DOC19/66375-3
DA 140-6-2005 MOD 3

Request for Agency Comments – Stockton Sand Quarry (DA 140-6-2005) - Modification 3

Stockton Sand Quarry Modification 3

Figure 4.1 Proposed expansion to extraction area

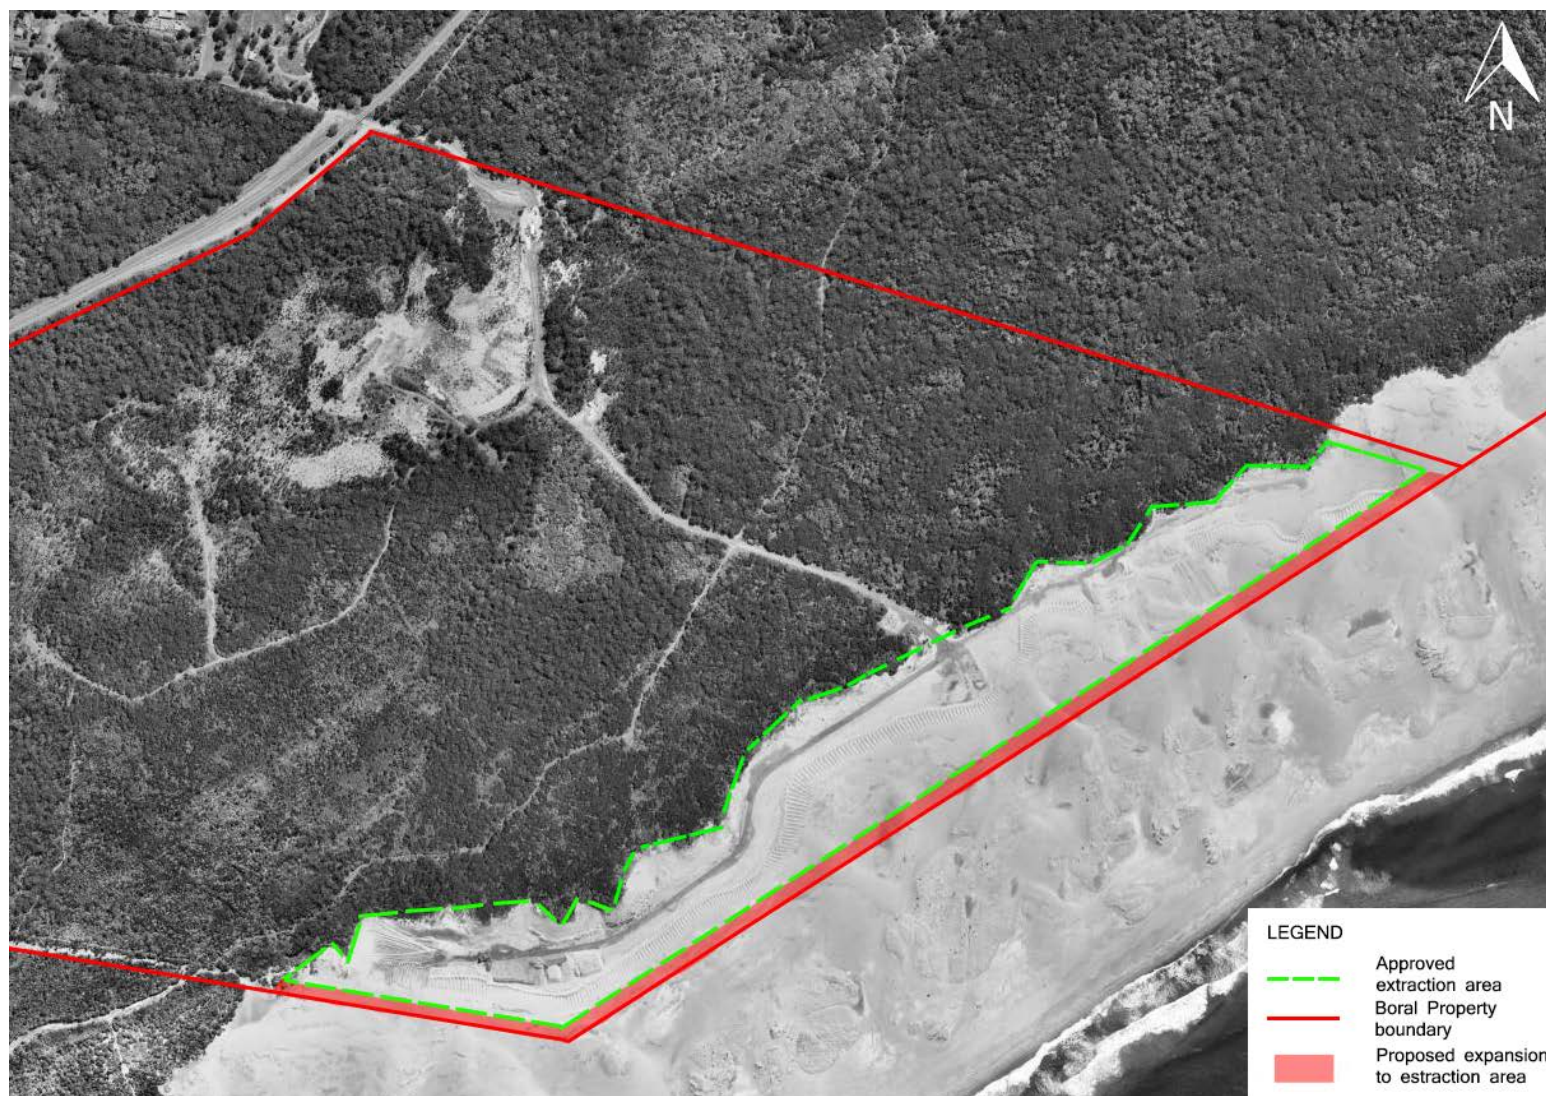
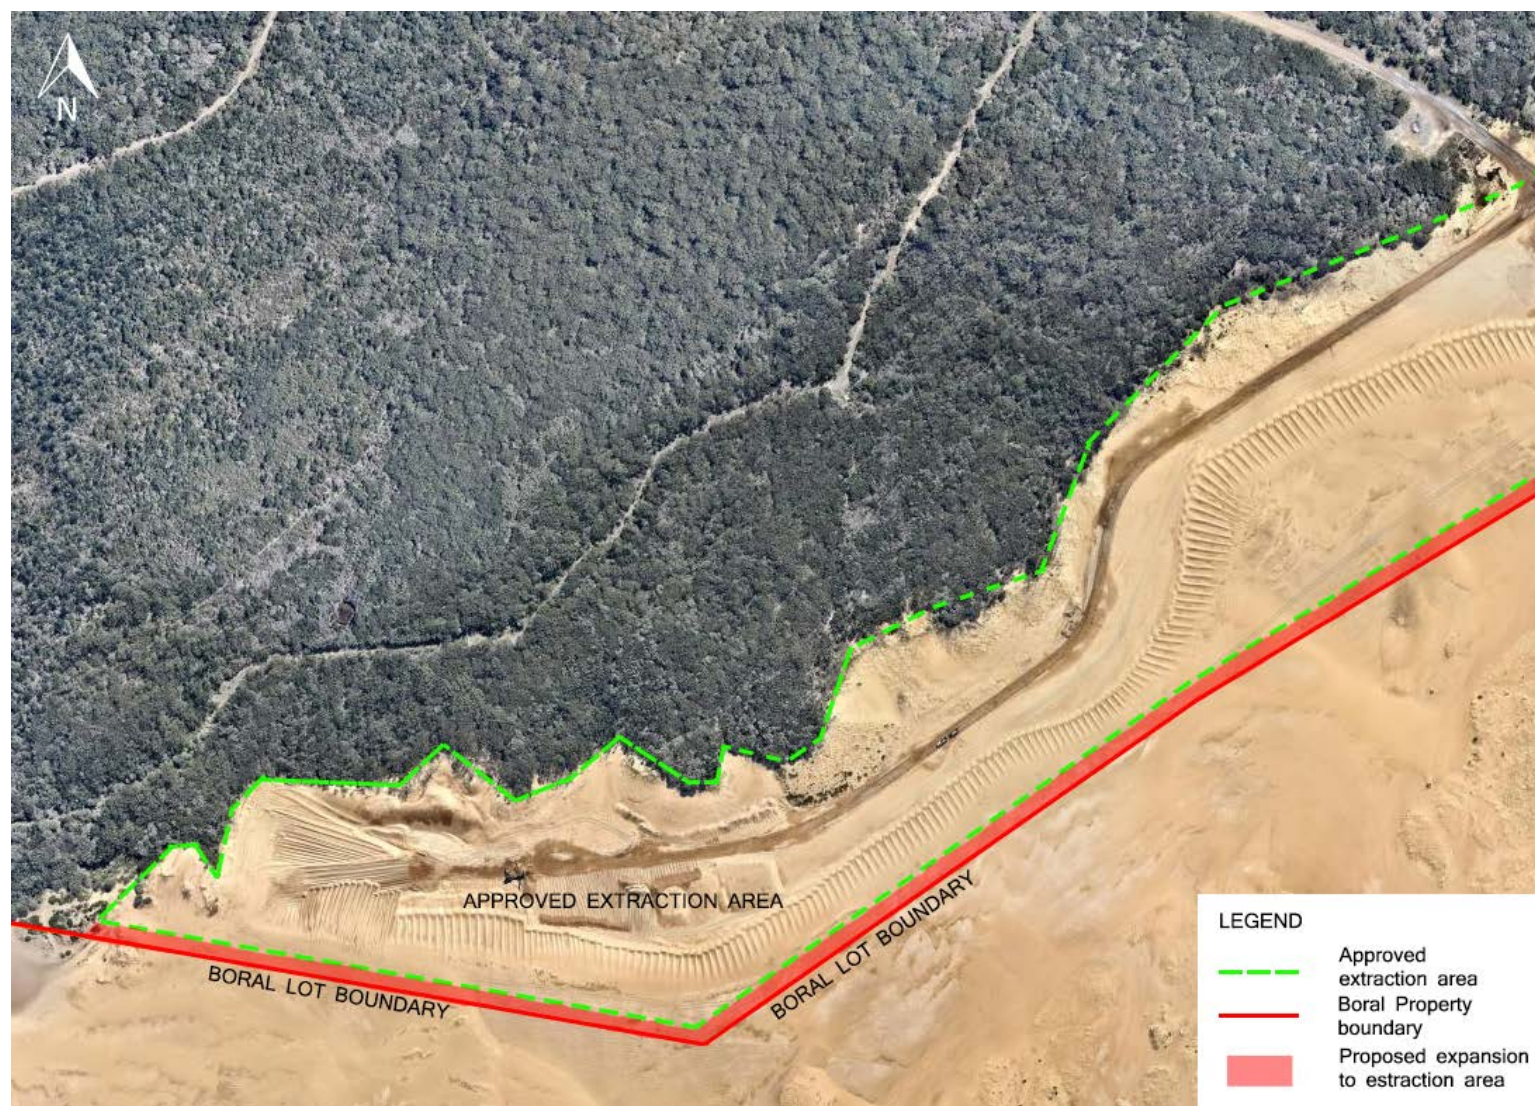
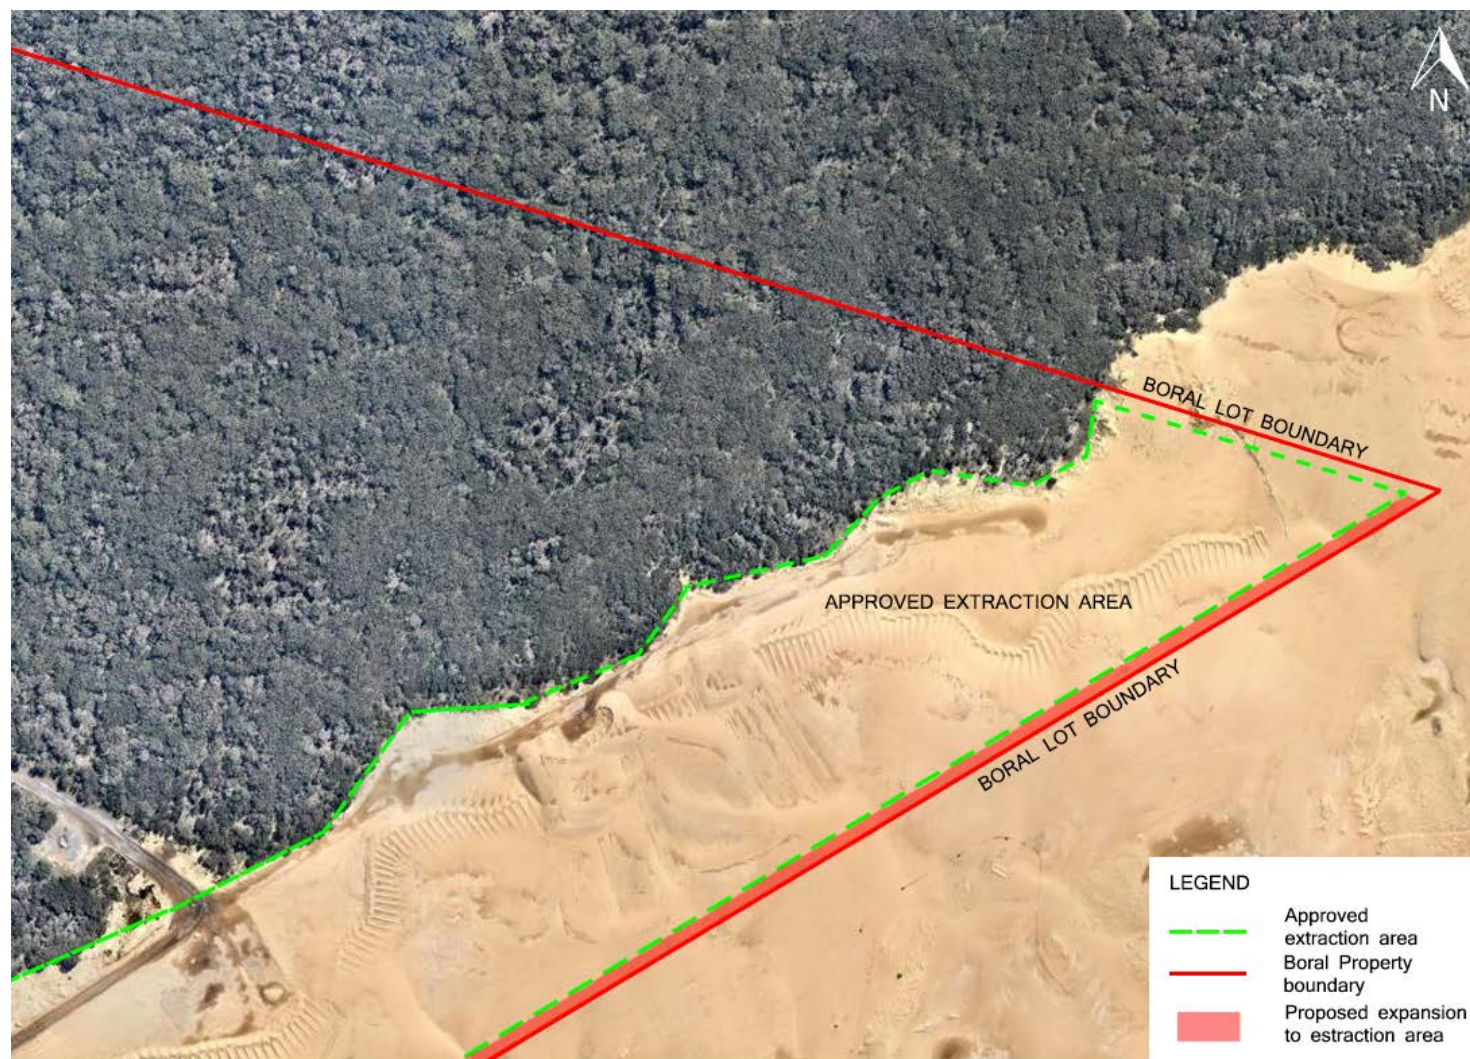
The proposed expansion of quarrying activities into the 15-metre buffer zone will result in disturbance of an additional 3.2 hectares of land. No biodiversity assessment has been provided with the modification application, despite the increased biodiversity impacts that may occur as a result of the proposal.

The proposed modification expands the active extraction area to include the 15-metre wide buffer area between the presently approved extraction area and the property boundary. Seaward of the property boundary is approximately 400 metres width of dunes to the shoreline. The extraction area and proposed modification are within the mapped Coastal Environment Area of the *State Environmental Planning Policy (Coastal Management) 2018*.

The current approval requires the revegetation of the batters and buffer area to control sand drift and stabilise the remaining dune following extraction. The proposed modification intends to remove this buffer area and revegetation requirement, allowing windblown sand from the dune sheet outside the property boundary (i.e. from the Worimi State Conservation Area) to fill the extraction area. As stated in Section 6.2.4 of the Environmental Impact Statement for the original development application:

The increased area of sand extraction without revegetation or dune stabilisation works will likely increase the rate of loss of sand from the neighbouring area of dune sheet adversely impacting the integrity of the dunes beyond the property boundary and natural coastal processes. As such, this modification does not meet the requirements of Clause 13 of the *State Environmental Planning Policy (Coastal Management) 2018*.

OEH recommends that the proposed modification be revised to retain the previously adopted dune stabilisation program to meet the requirements of Clause 13 of *State Environmental Planning Policy (Coastal Management) 2018*.
